**Our ref:** 25\_34206\_P

**Your ref:** H12-1156-25

**Site Location:** Barns to Rear of 60 South Drove,  
Lutton Marsh, Spalding, PE12 9NT

**Summary of Proposal:** Demolition of barns  
and erection of self-build dwelling

TITLE
 SITE LOCATION & EXISTING SITE LAYOUT

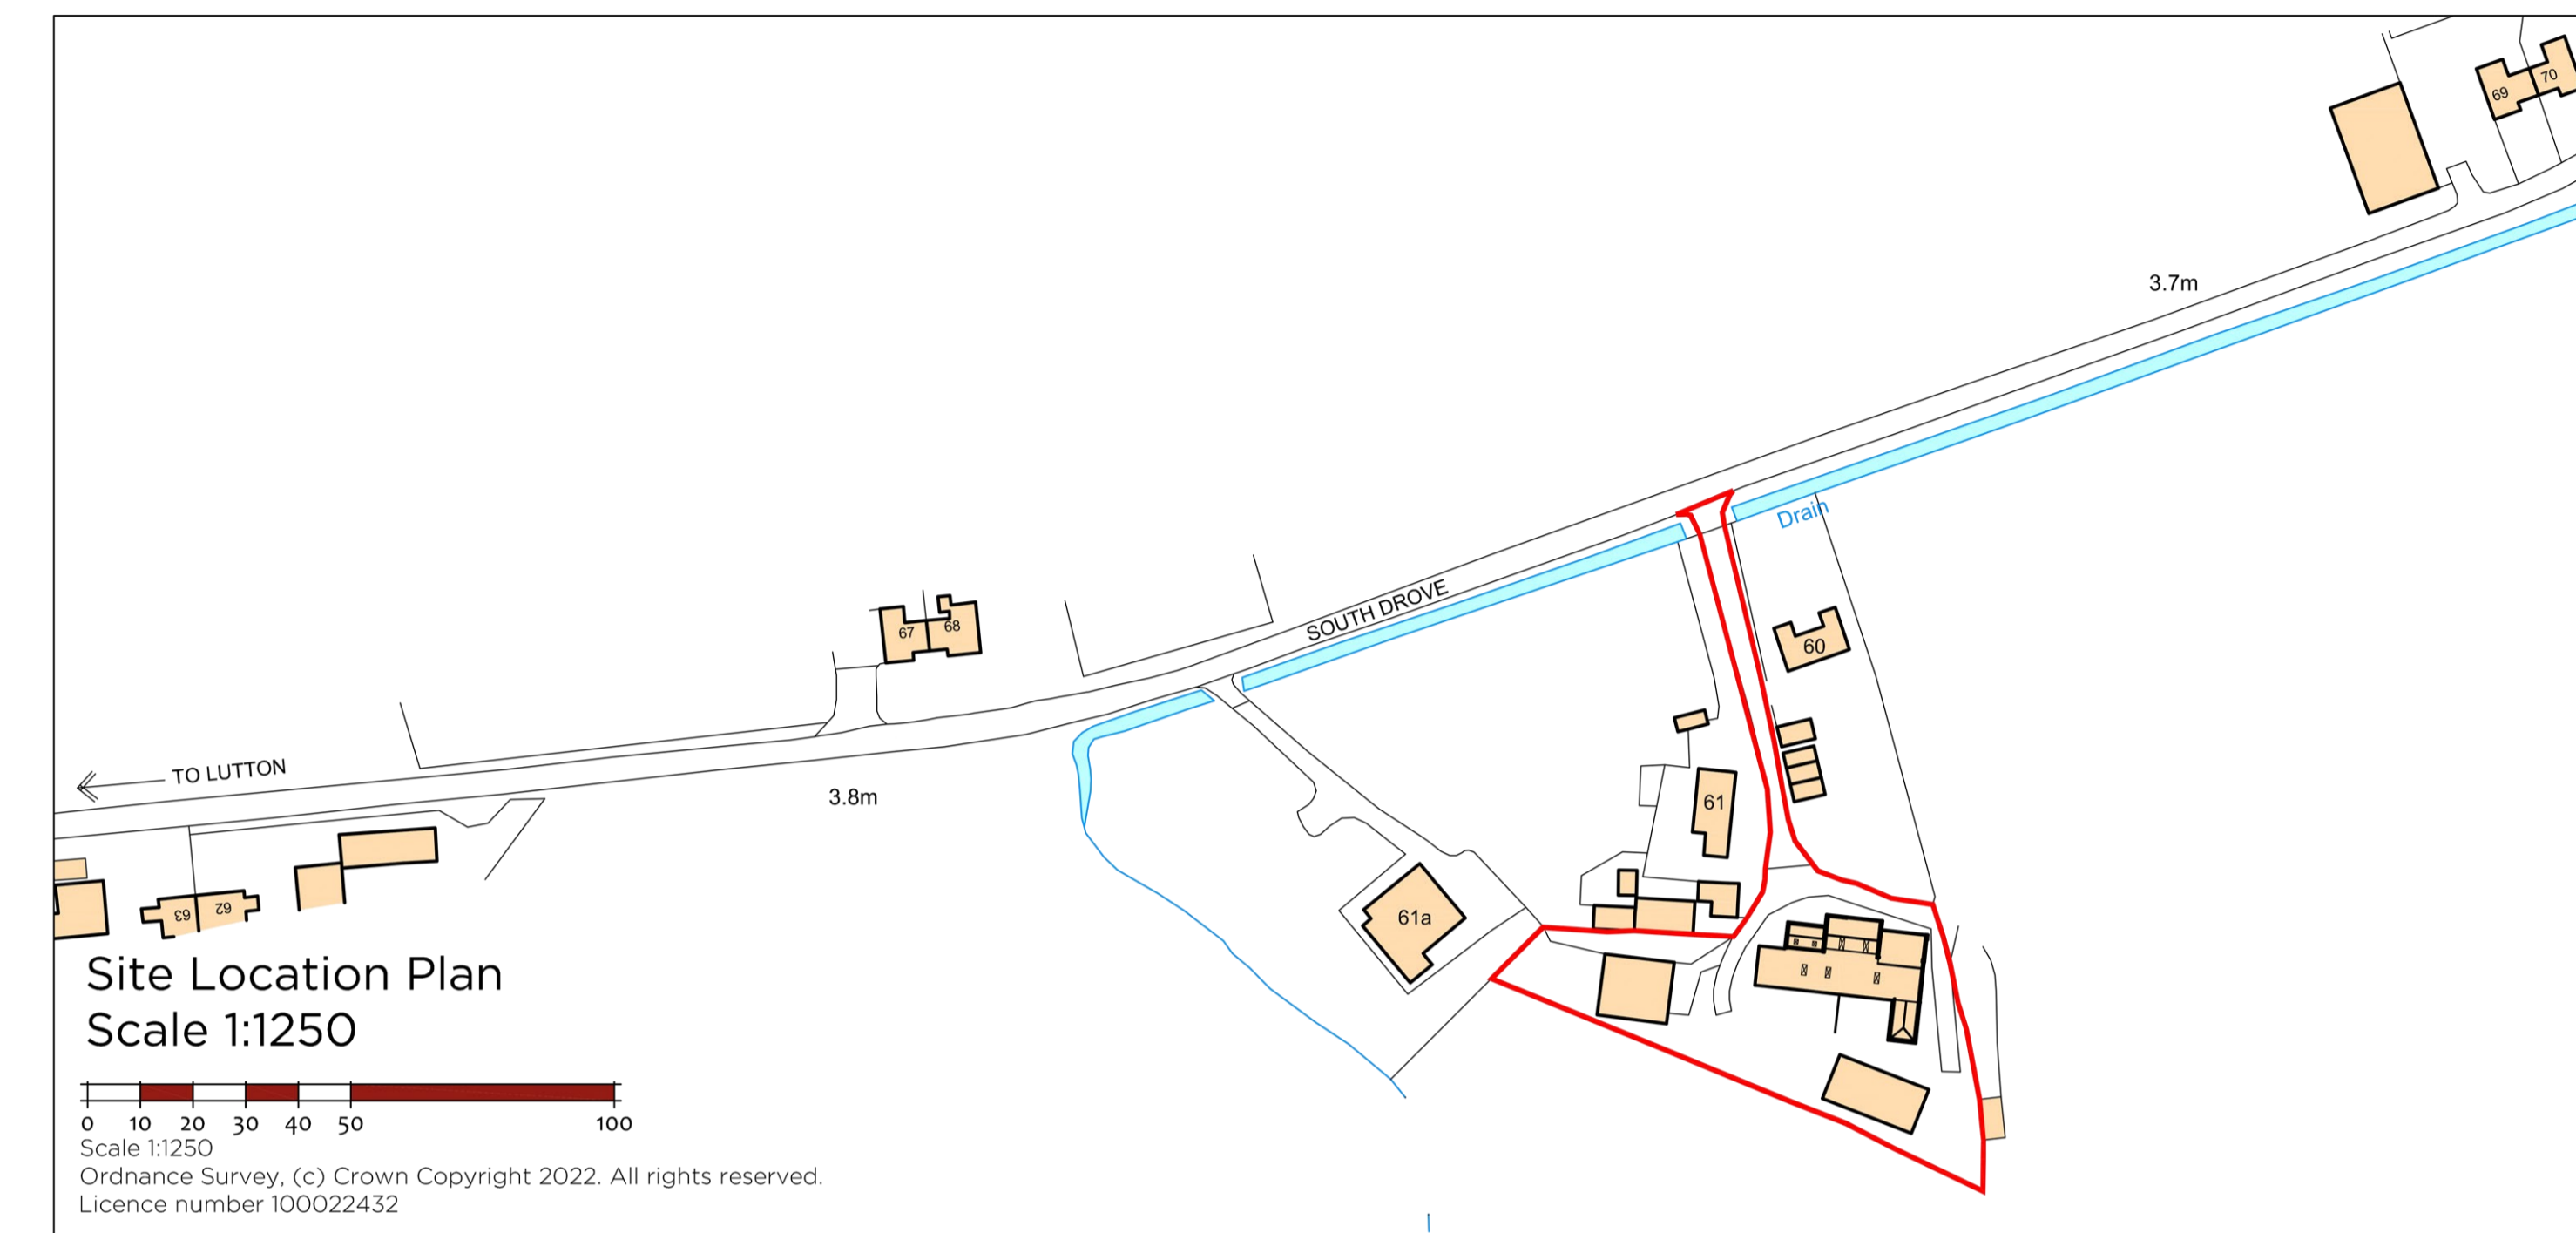
We note the presence of watercourses which are not maintained by the Board (riparian watercourses) adjacent to (a) the site entrance to the north and (b) at the southern site boundary. Whilst not currently proposed, should the applicant's proposals change to include works to alter either riparian watercourse, or if works are proposed to alter any watercourse at any time in the future, the Board's previous written consent would be required under the Land Drainage Act 1991 (and Byelaw 4).
